RE: Response to Department of Planning, Industry and Environment

Lang Walker AO Medical Research Building, Macarthur

DPIE, Transport comments

CANOPY COVERAGE

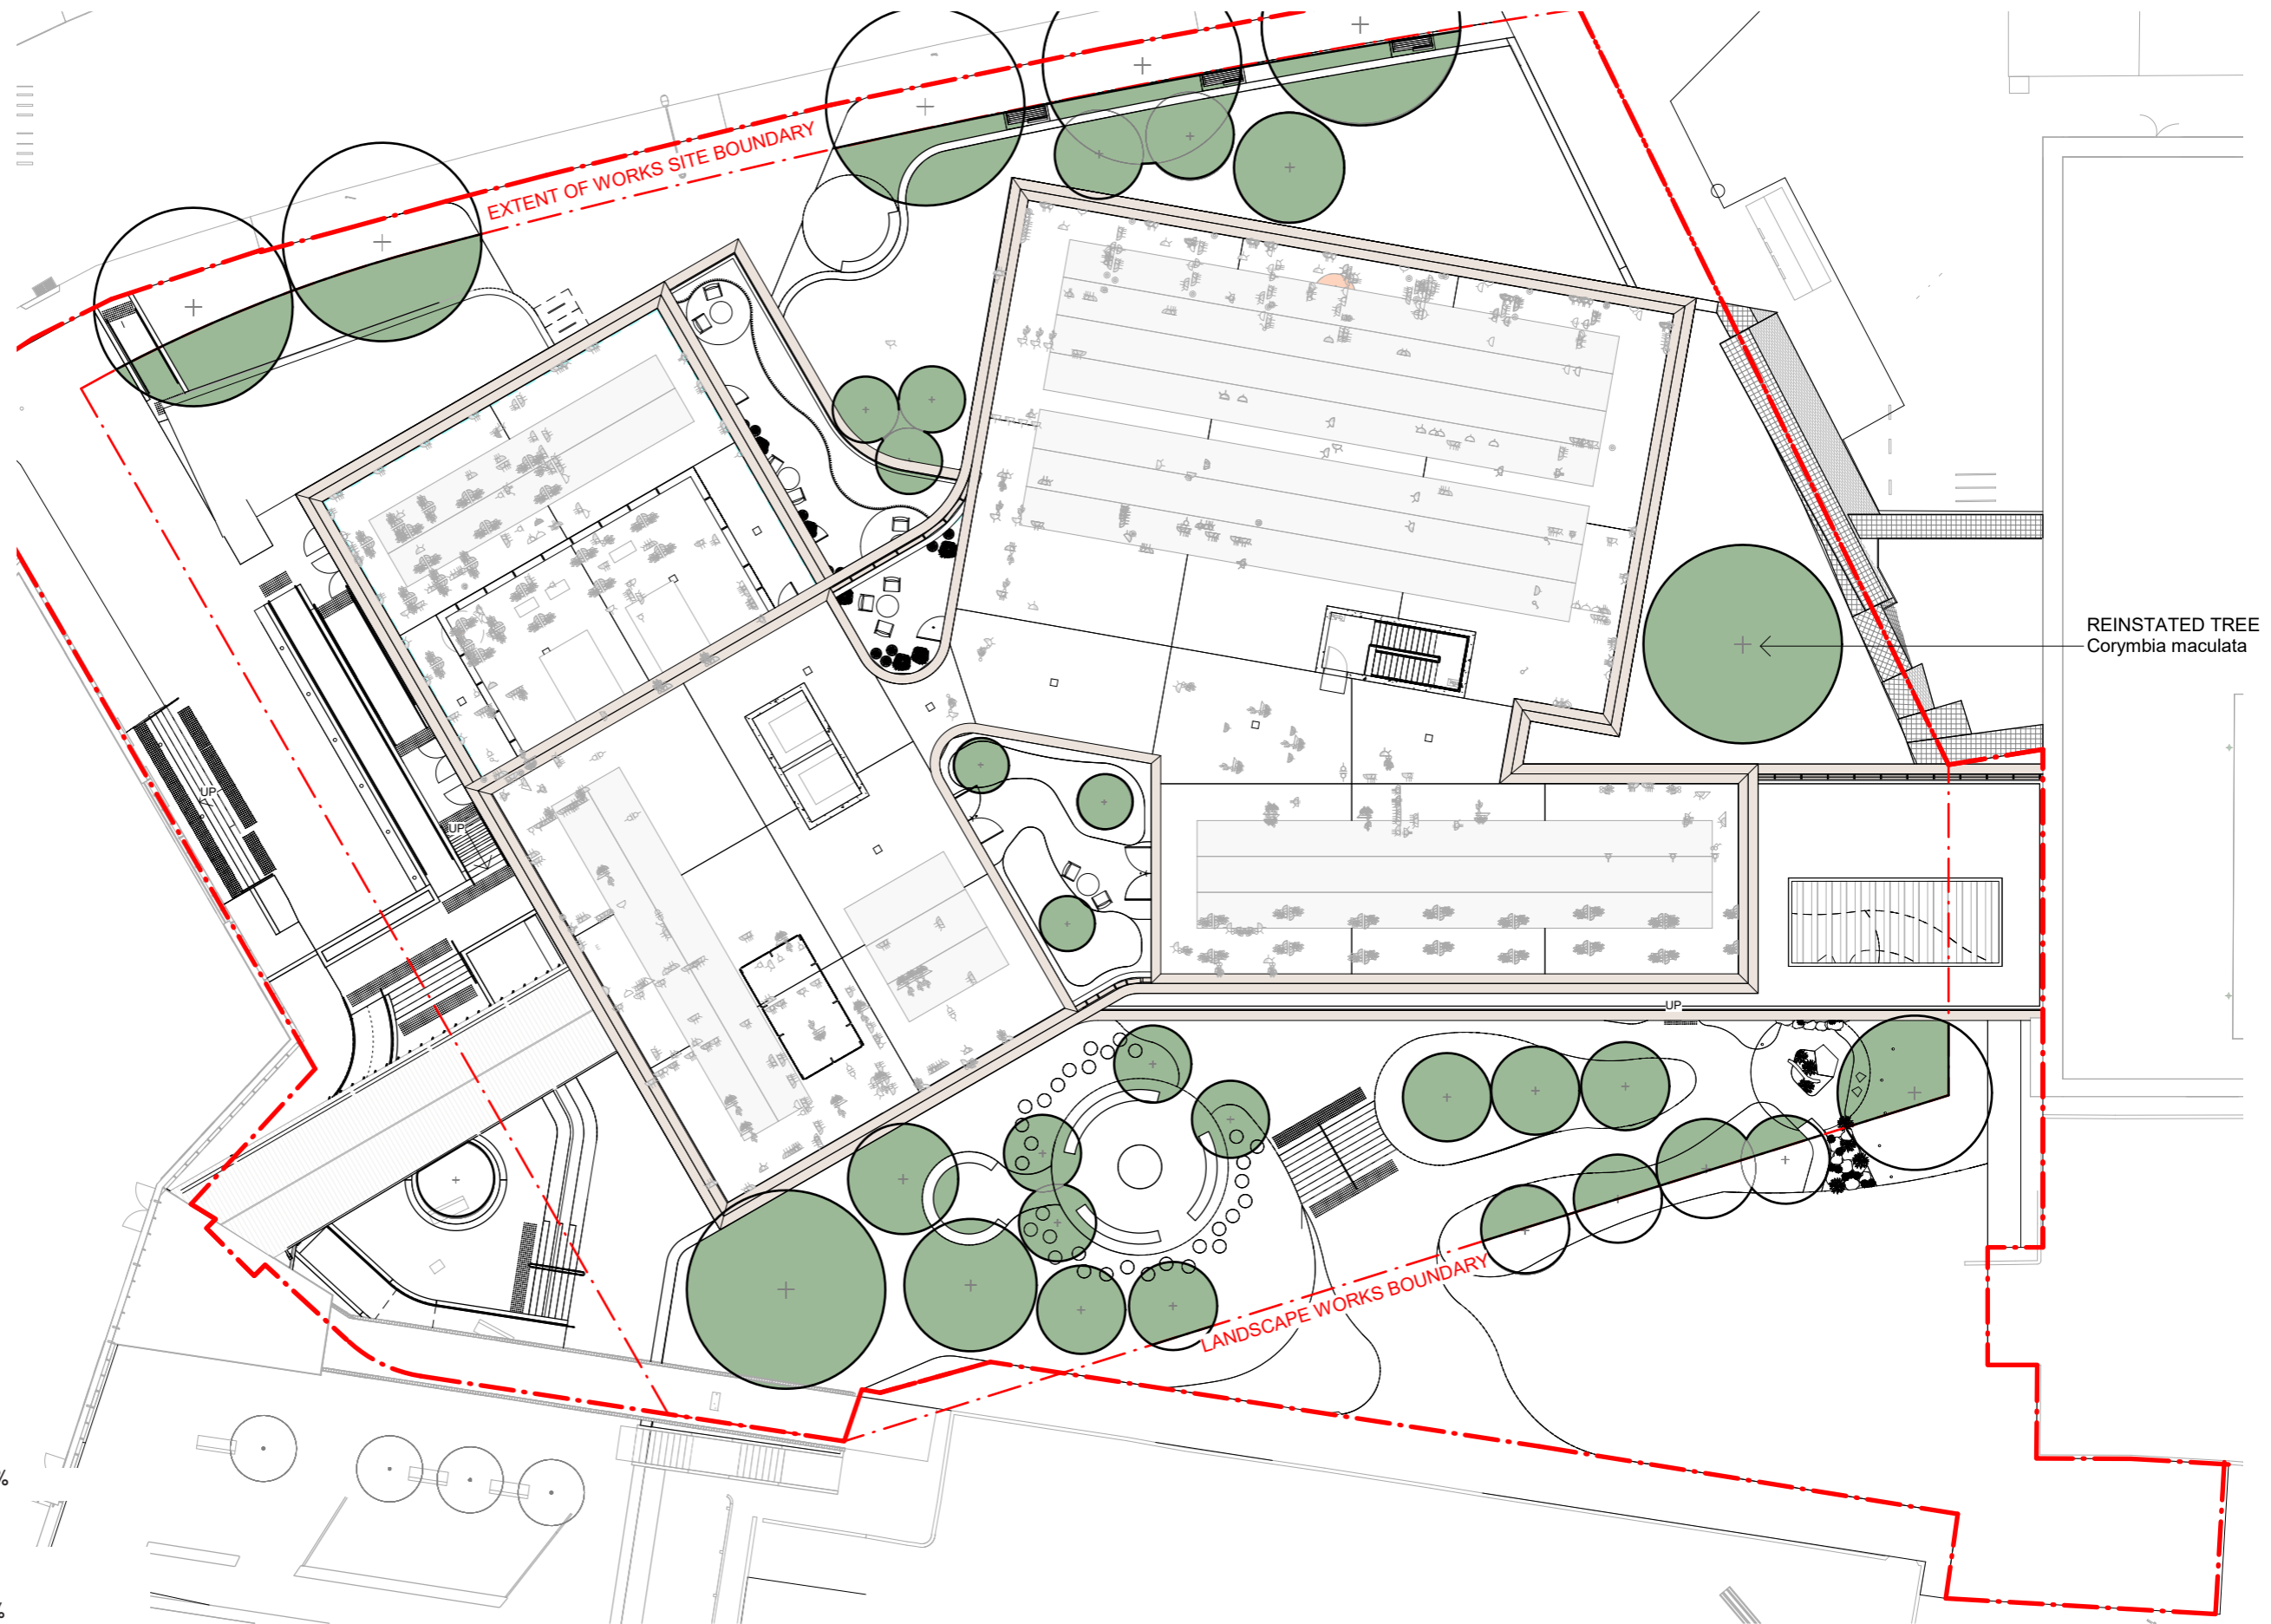
O. I can see the tree coverage on the village green has been reduced, maybe for this reason. The tree reduction needs to be balanced, aiming for 40% canopy coverage. Also, selecting particular tree species could allow for good sightlines but still achieve additional canopy cover.

Response: Trees were removed from the grassed area of the village green as they fell outside the revised site boundary. Canopy coverage abides by the Rural Fire Service restrictions including the following: 'Planting does not provide continuous canopy to the building ie. Trees or shrubs are isolated or located in small clusters.'

PLANTING PLAN LG01&02

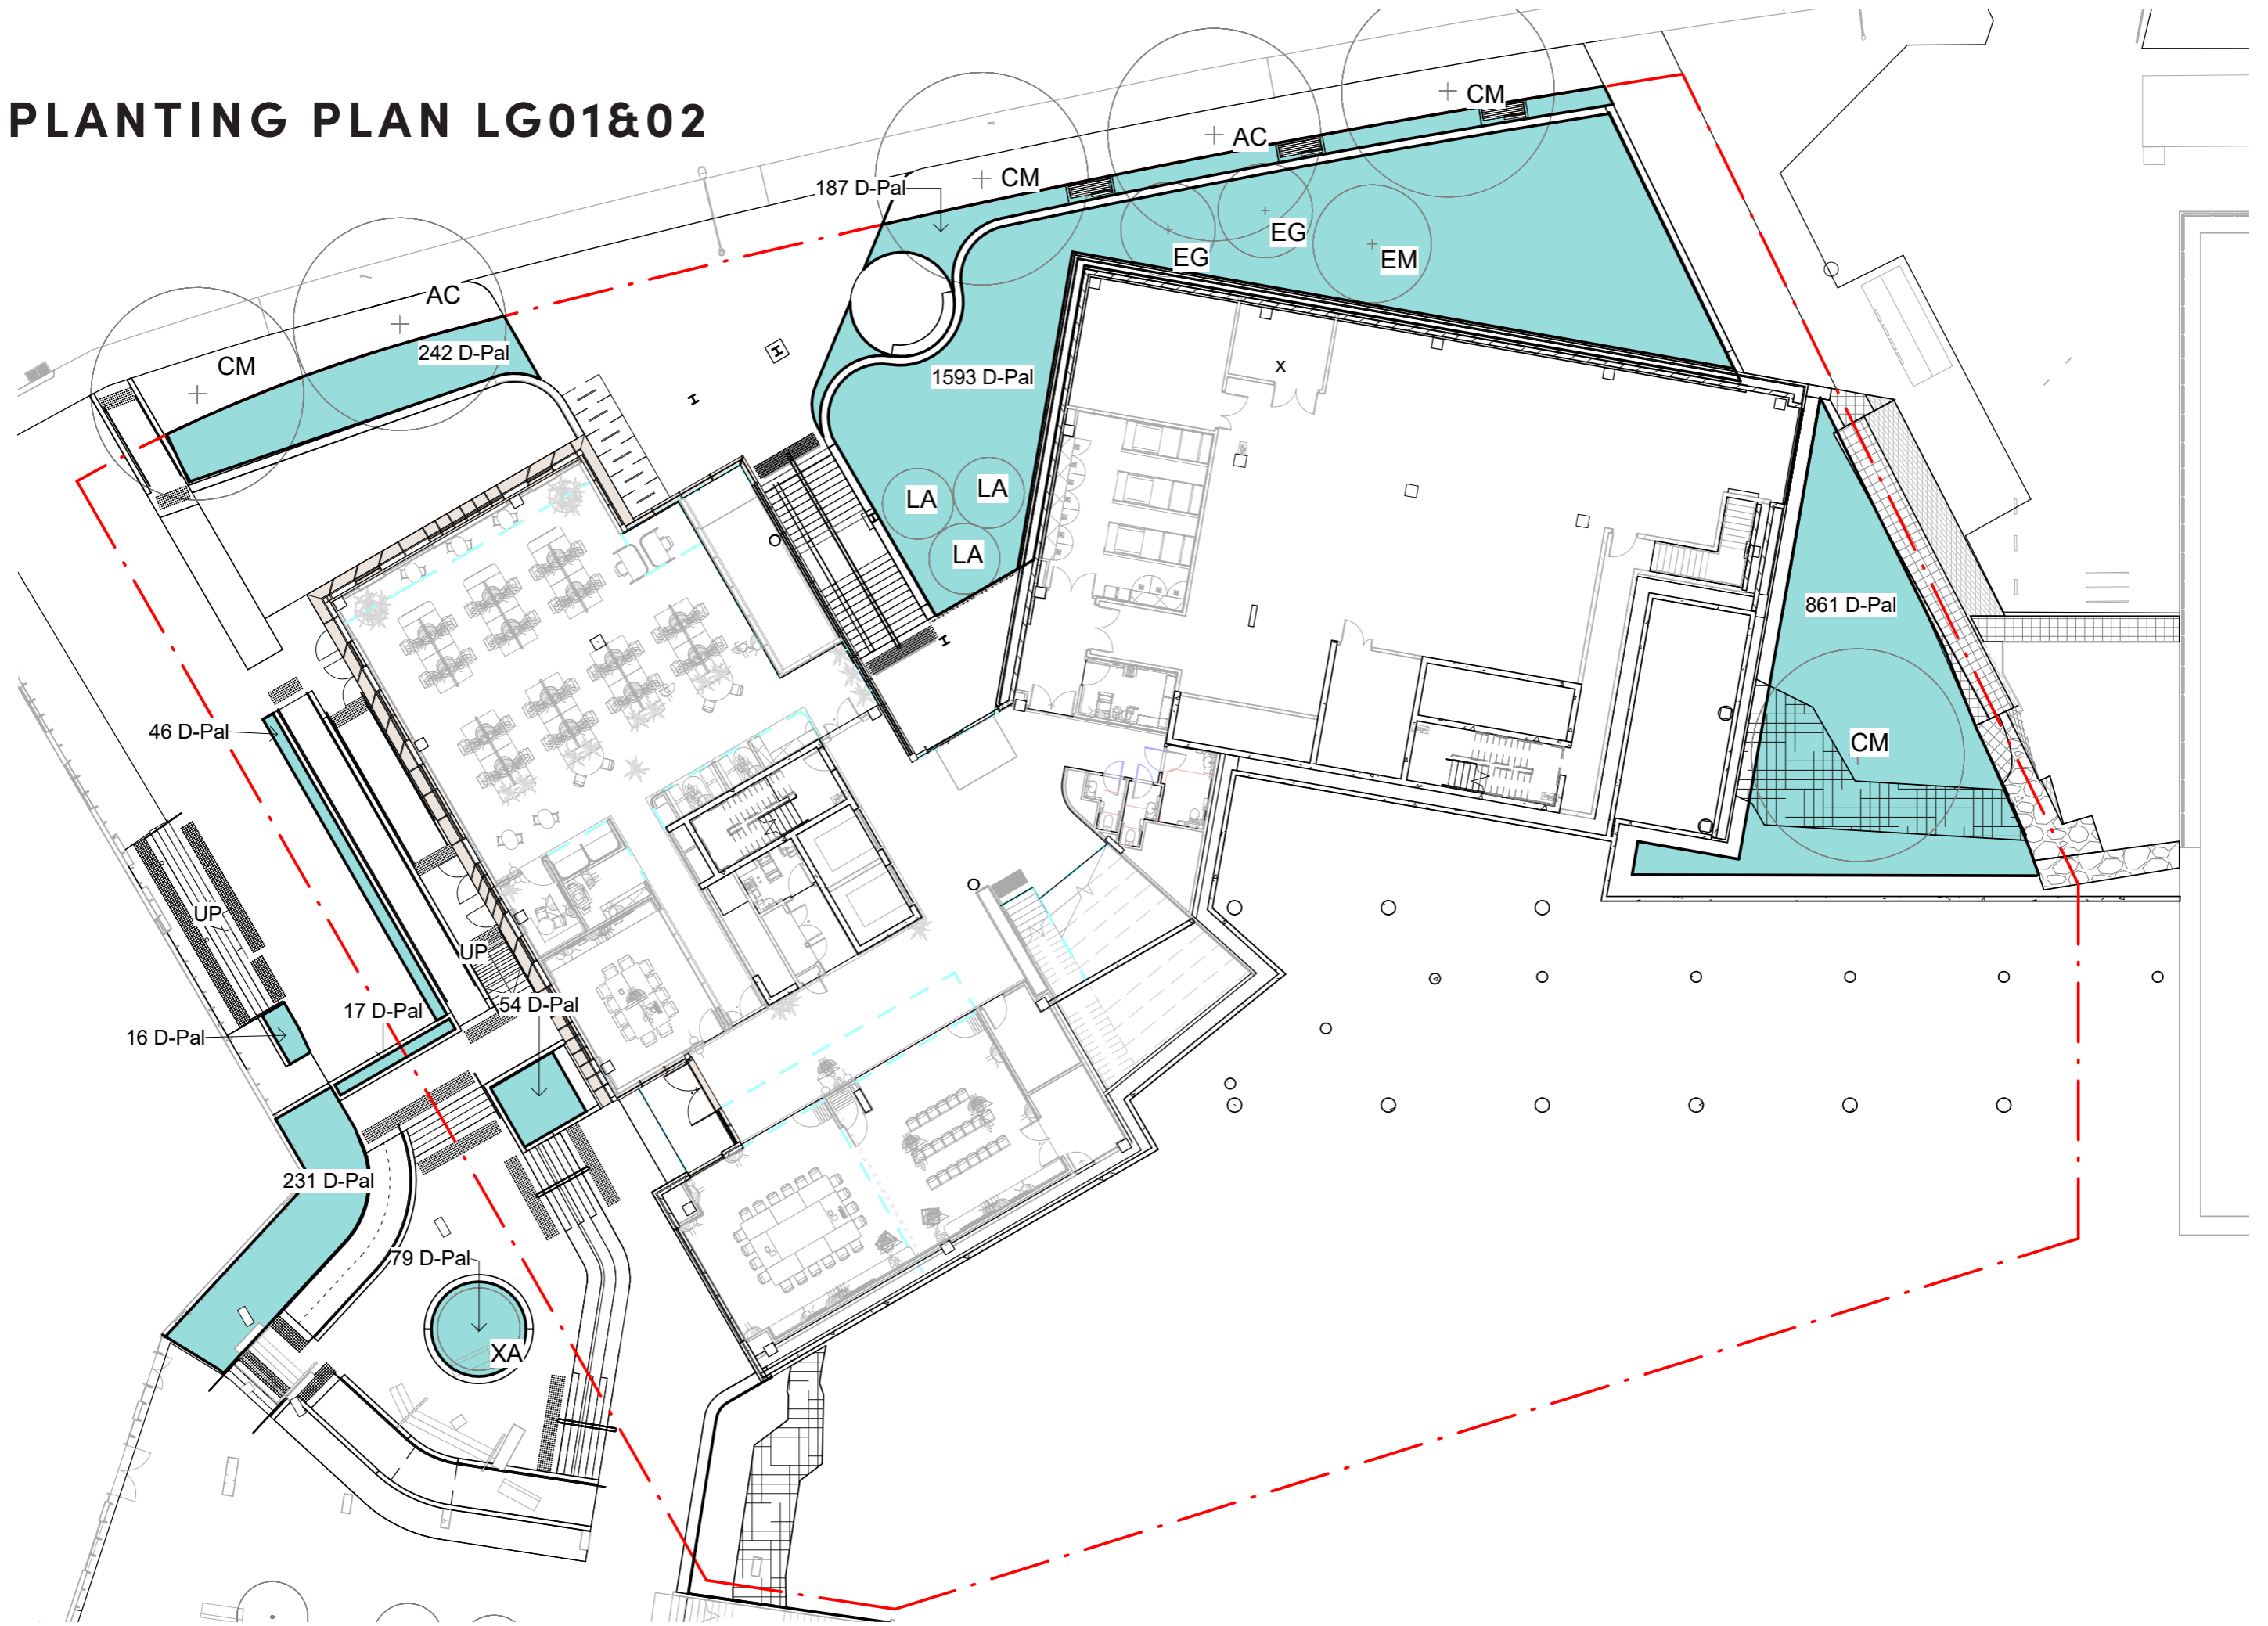
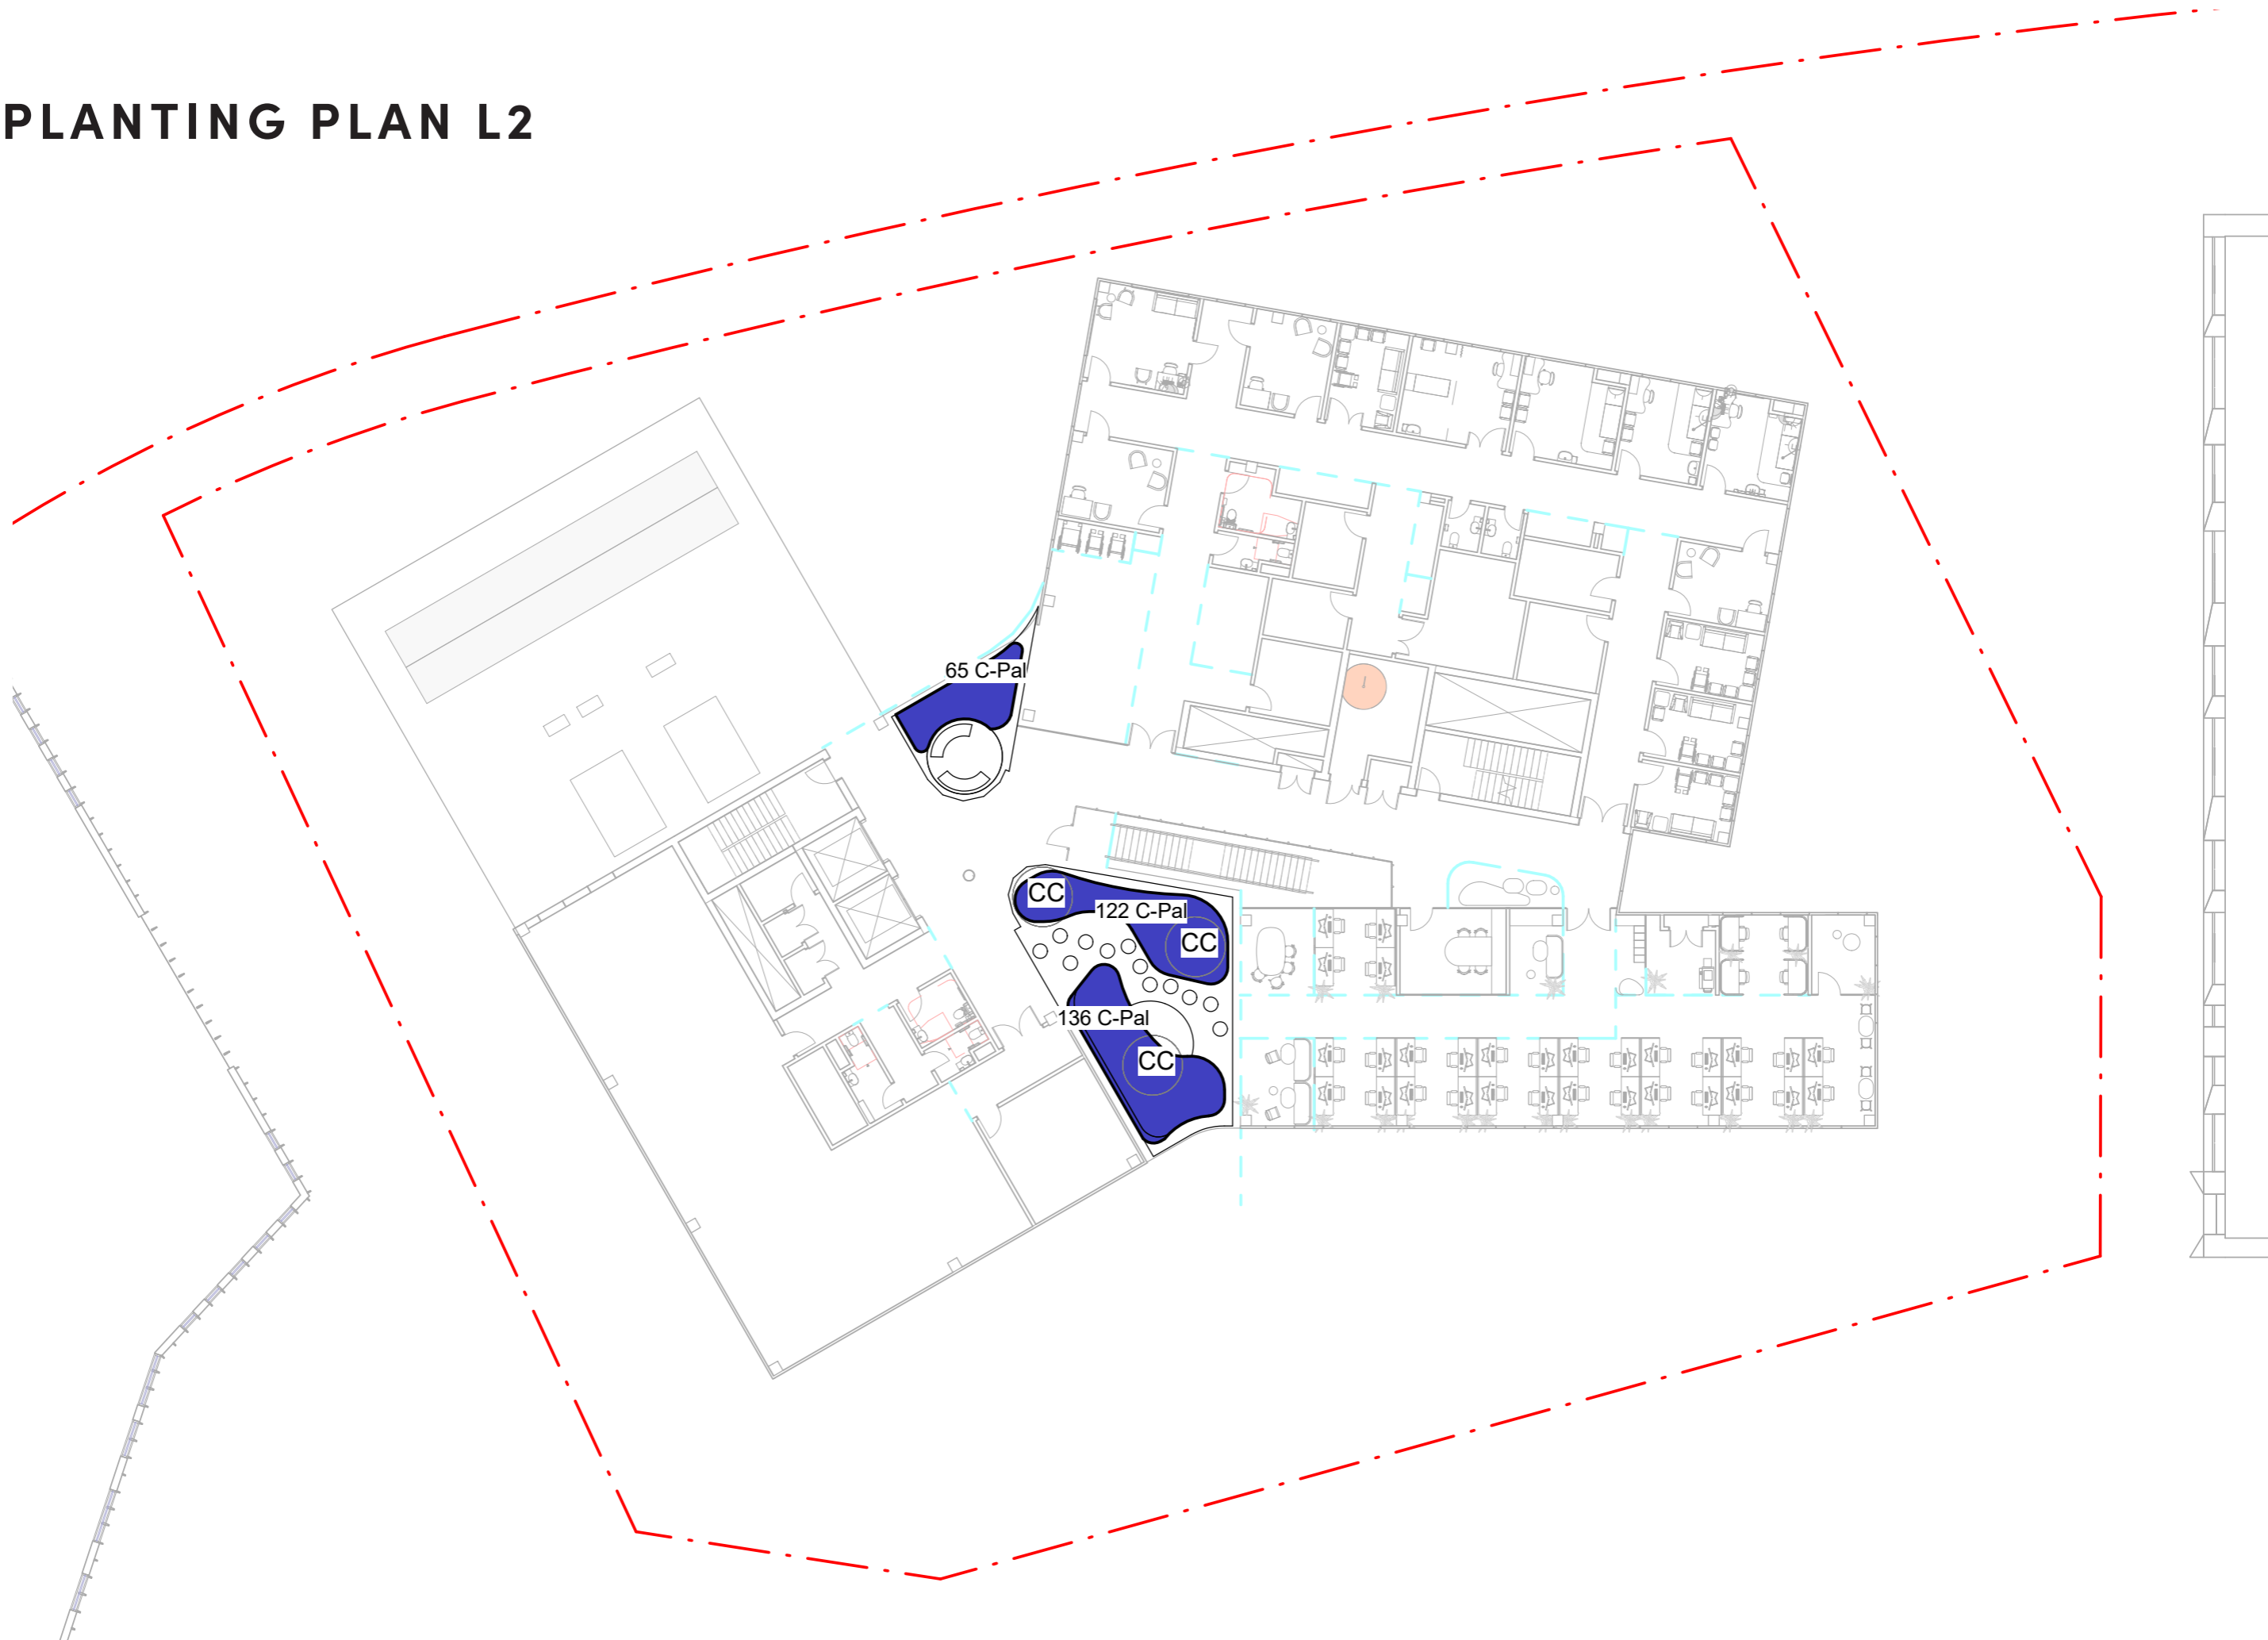
N. The tree shown during SDRP 03 within the northern landscaping has been removed. Ideally, this tree should be reintroduced to increase canopy cover.

Response: Refer pg. 29 Planting Plan of Landscape SSDA report for re-introduced tree.
